# Comments for Planning Application CA/20/02636

Application Number: CA/20/02636

Address: All Saints Church Church Street Whitstable Kent CT5 1PG

Proposal: Installation of gate to church car park.

GATE

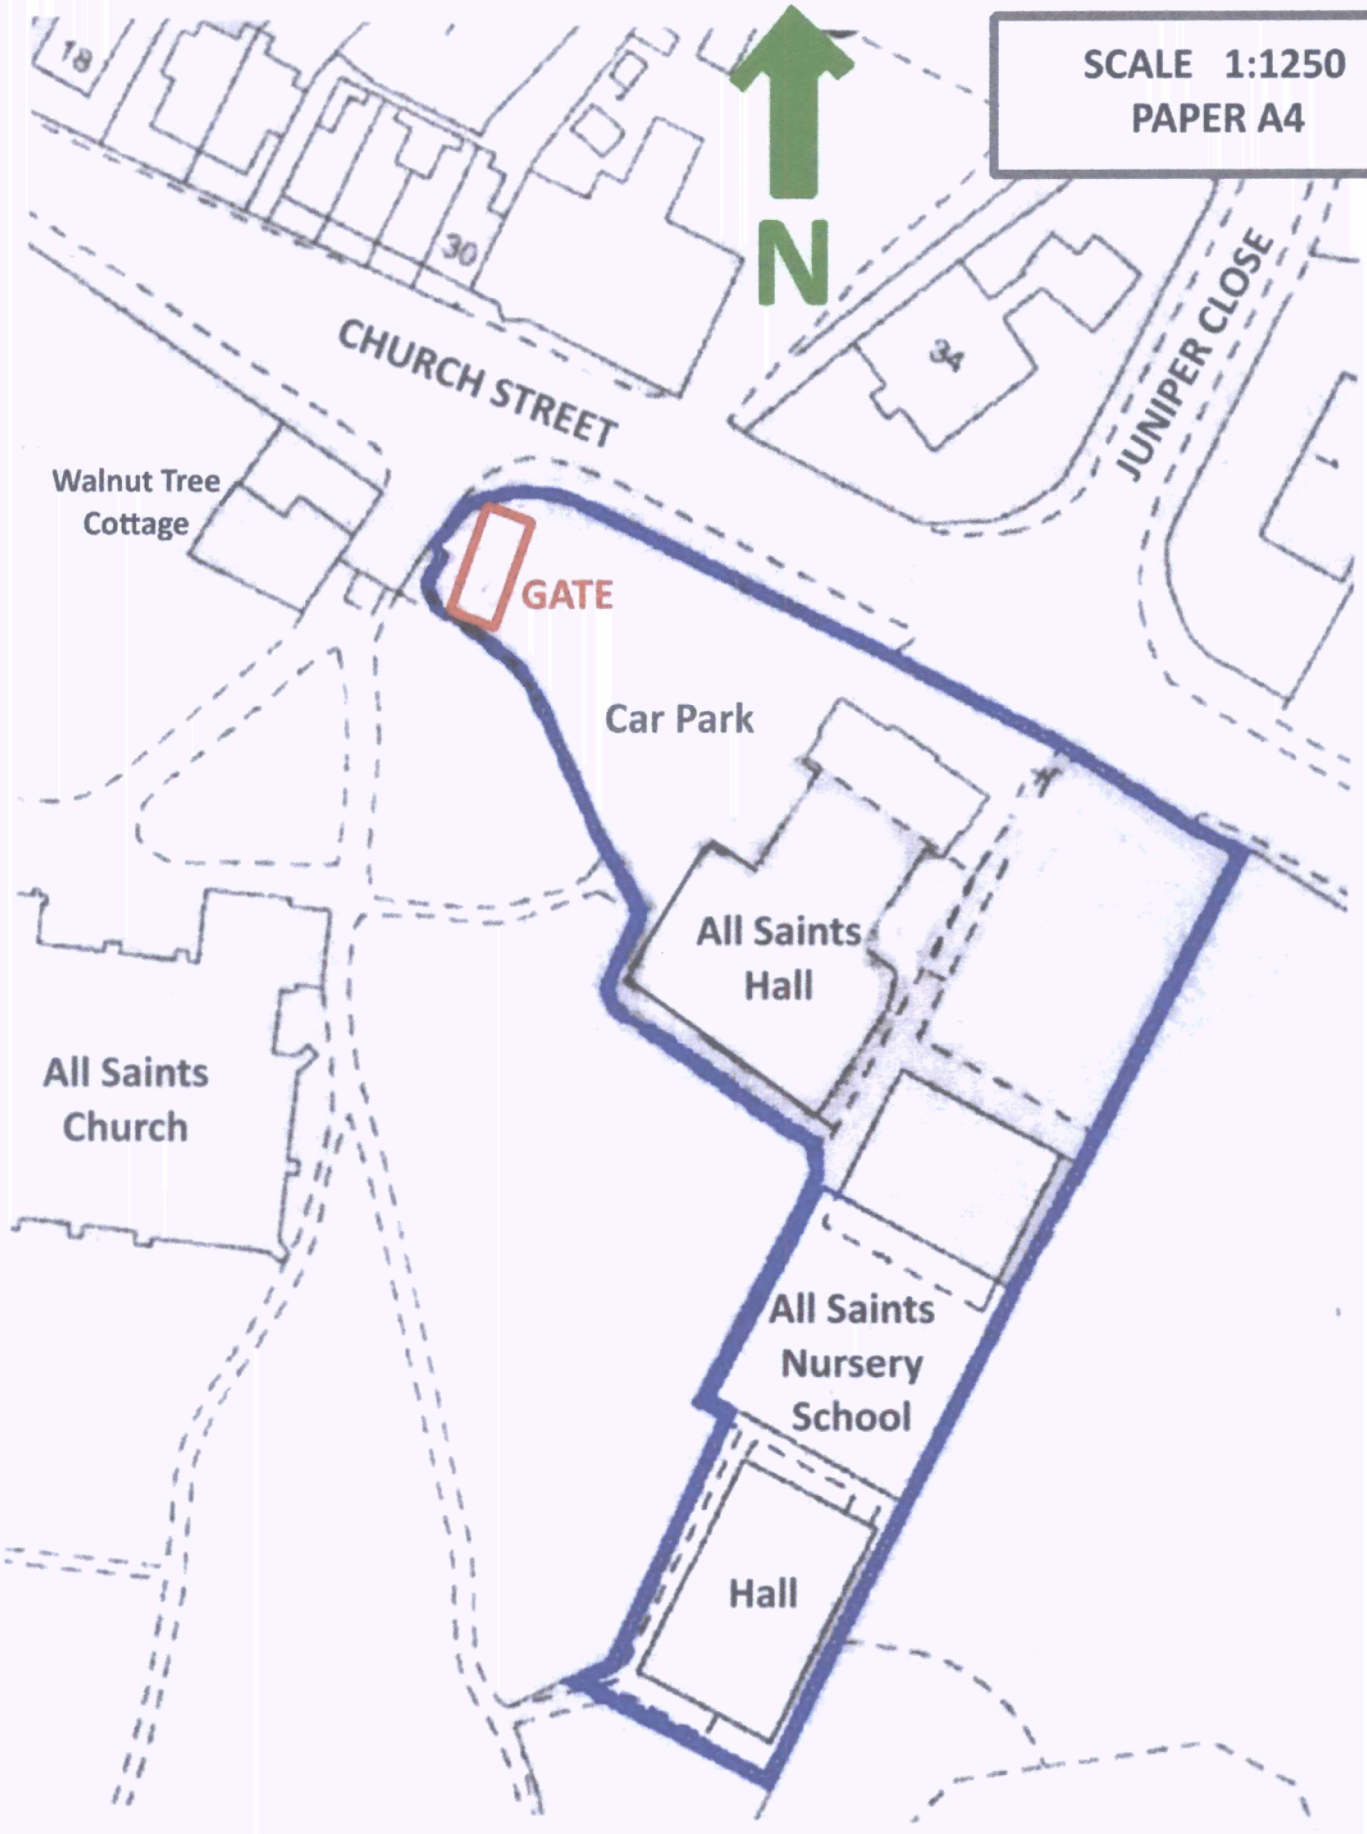
The proposed gates are not in keeping with a conservation area.

Due to the proposed positioning of the gates, obstructions would be caused by cars going in and out whilst they stopped to open and close the gates. This includes putting pedestrians, people with disabilities and using mobility aids at risk as they traverse across this area if it is blocked by a car. It also increases the risk of accidents by other traffic due to the obstruction that would be created. It is regularly observed that cars travel through this stretch of road speedily which causes an additional risk of accidents.

Increased noise to neighbours and air pollution caused by idling engines whilst opening and closing gates.
